Our Ref: DOC19/592501

RE: Notice of Exhibition – Royal Hall of Industries, 1 Driver Avenue, Moore Park (SSD 9726)

I refer to your email dated 10 July 2019 inviting comments from Heritage, Department of Premier and Cabinet (Heritage DPC) and advice on recommended conditions for the above mentioned State Significant Development application for the Royal Hall of Industries (RHI) at 1 Driver Avenue, Moore Park.

1 SITE PLAN  
1:500

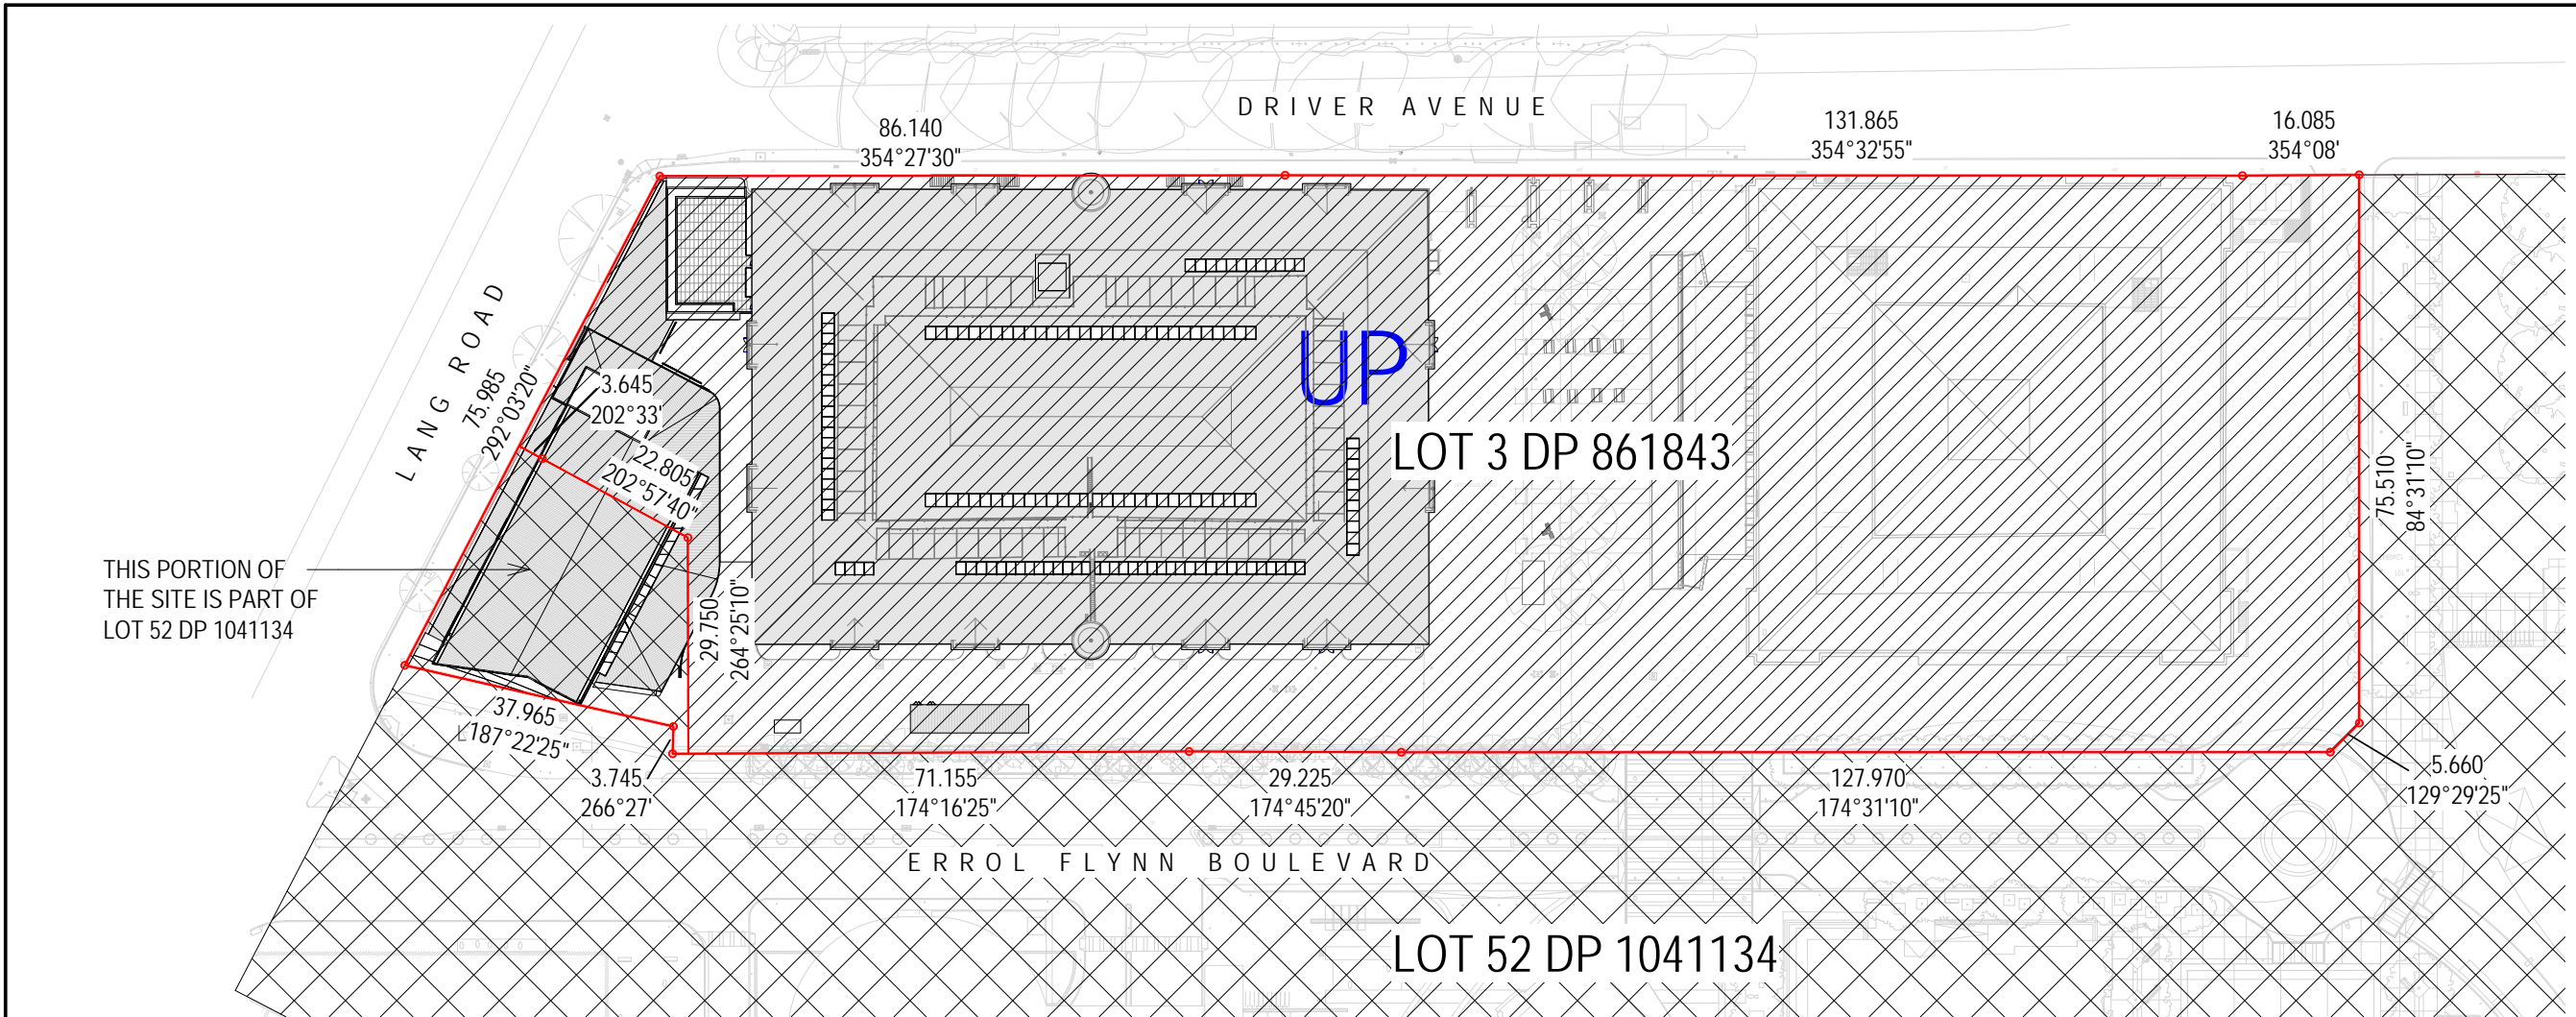
The HIS states that the proposed new 'Swifts building' has been designed to ensure it is sympathetic to the RHI building, through the siting, massing and scale of the built form. The new building is located in a historically back-of-house area which follows the same alignment as Lang Road and away from the principal (eastern) façade of the RHI building. However, it is recommended that:

- ***The siting of the new building provides an appropriate setback from the early brick wall along Lang Road and Driver Avenue, as it informs the early layout of the site and contributes to its historical and aesthetic values.***
